Address: 10 Gees Court, London, W1U 1JJ,

Proposal: Display of a non-illuminated projecting sign measuring 50cm x 60cm; a non-illuminated fascia sign measuring 20cm x 90cm; and an awning measuring 470cm x 180cm.

Thank you for your application received on 31 October 2023. I am writing to inform you that your application is incomplete for the following reason(s):

01 EXTERNAL ELEVATION - AWNING RETRACTED 1:100 @ A3

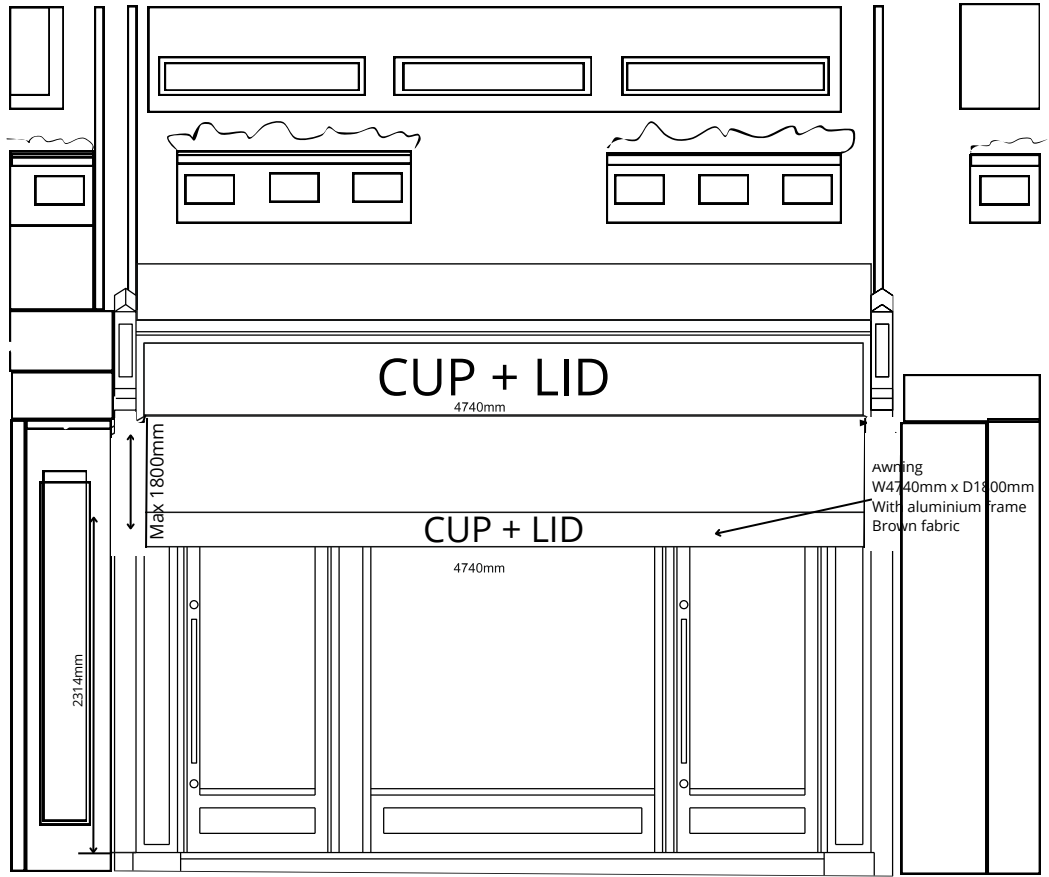
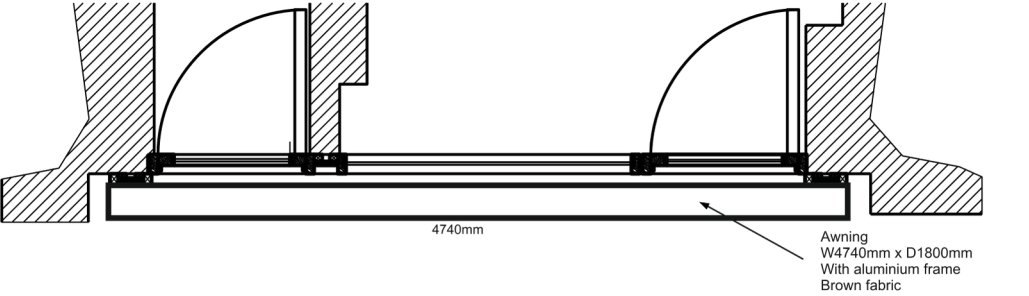
1 Please update the elevation drawings to illustrate the context of the host building.
